From: Tim Screen <Tim.Screen@Cherwell-DC.gov.uk>
Sent: 02 November 2020 16:44
To: Bob Neville <Bob.Neville@cherwell-dc.gov.uk>
Subject: RE: 20/02453/F - Hornton Grounds Quarry Hornton

Visual Appraisal

Further to consideration of CAT's visual assessment section of the LVIA I confirm that I require additional information, as follows:

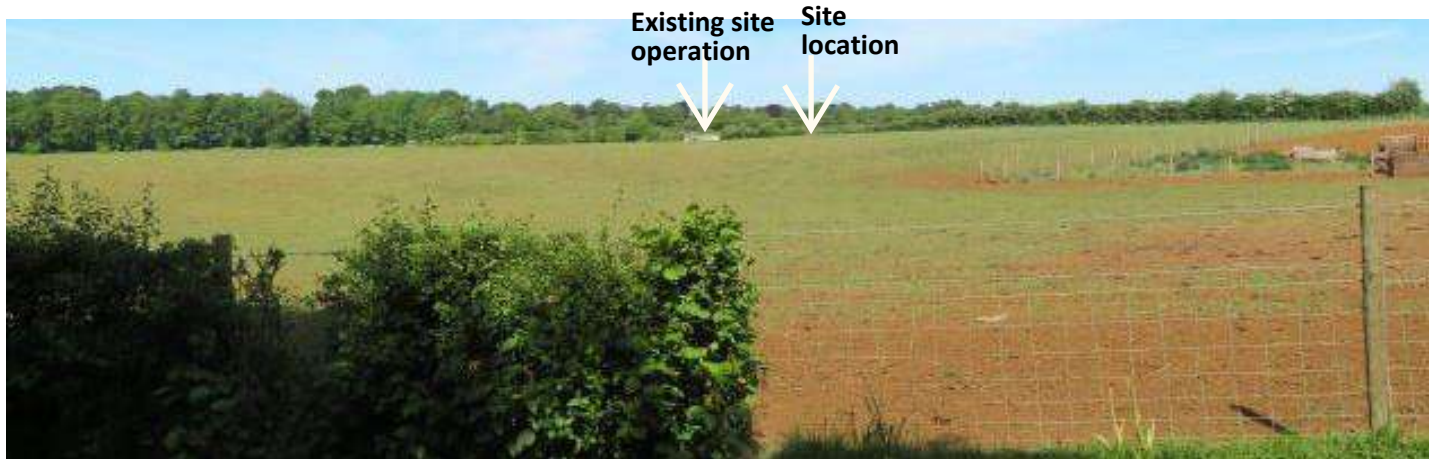
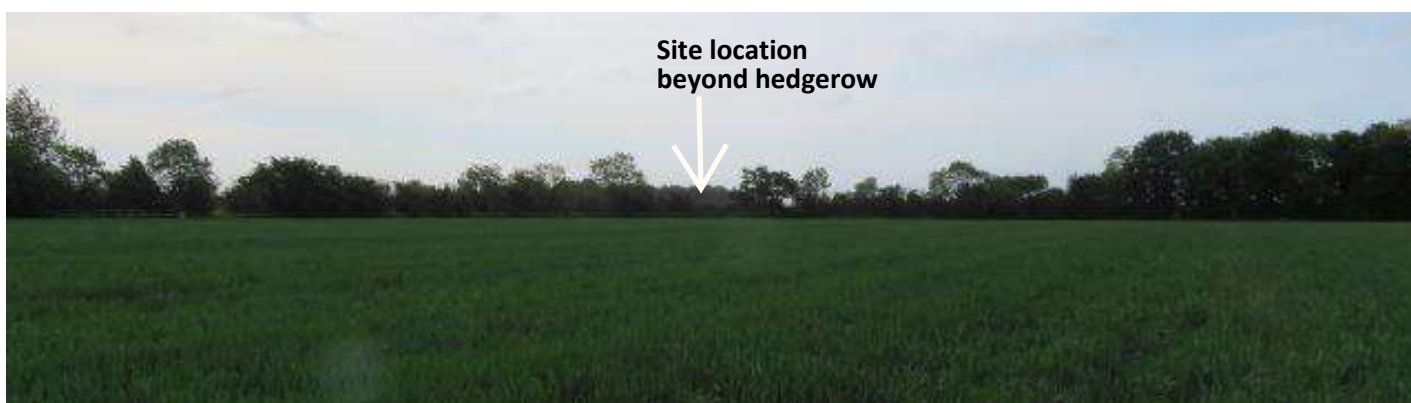
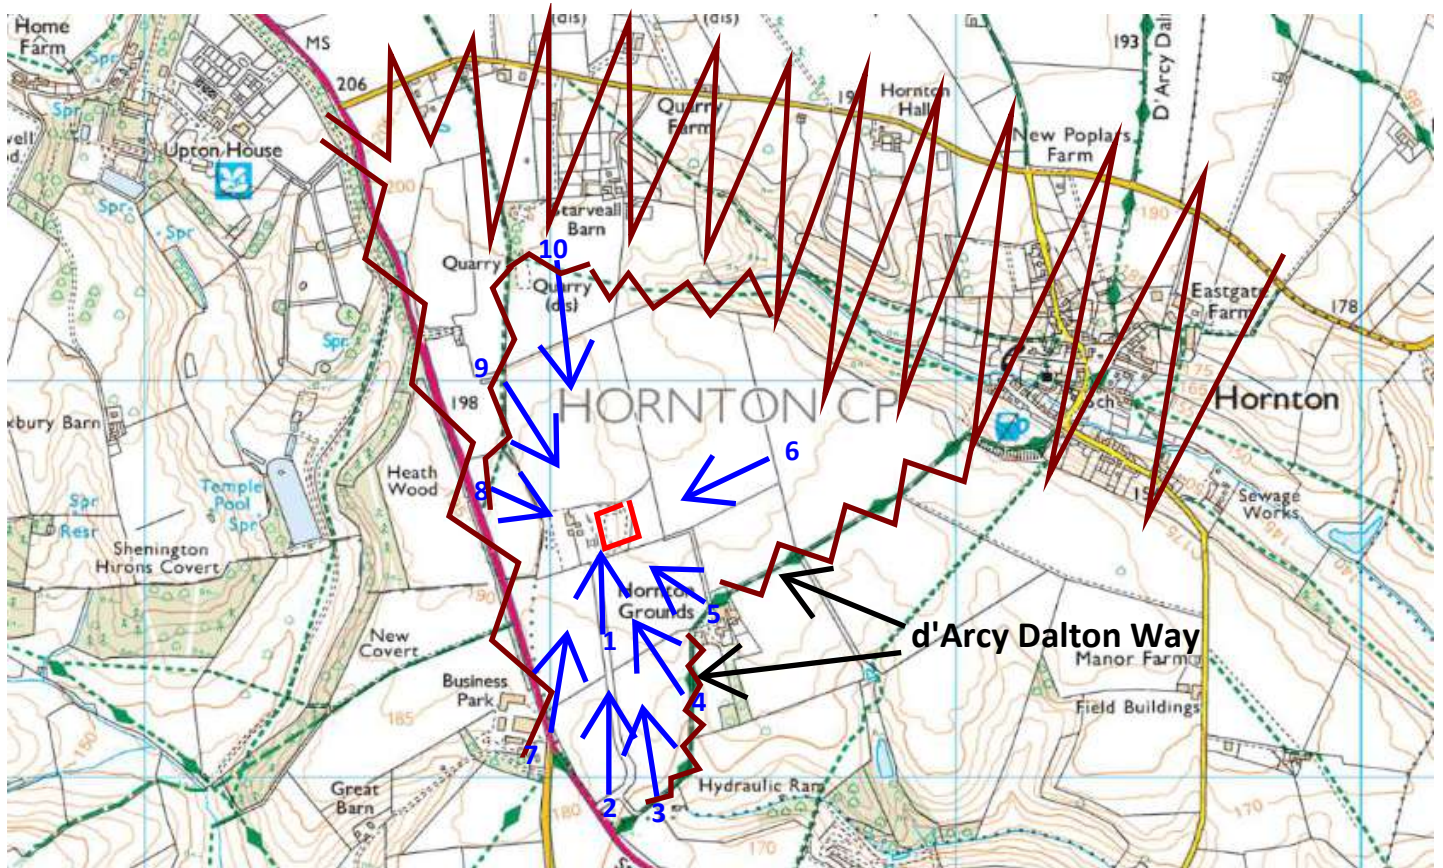
I would change the sensitivity weighting of receptors that use the important d'Darcy Dalton Way to **High**, especially around the highway access, approx. 170m - refer below. Site is hidden successfully by intervening topography most notably with the Wooded Pastures, Valleys and Slopes (refer below) intervening established hedgerow along the north of d'Darcy Dalton Way. Even the 38 m approx. gap in the hedgerow does not allow visual experience of the site due to intervening field boundary hedgerows. The site is well hidden from the other PRow due to intervening hedgerows, woodland, and topography (the floor bottom of the quarry), however, as mentioned

The sensitivity of d'Arcy Dalton Way is generally high because of its public perception as an important route which is very well used. Refer to The CPRE:
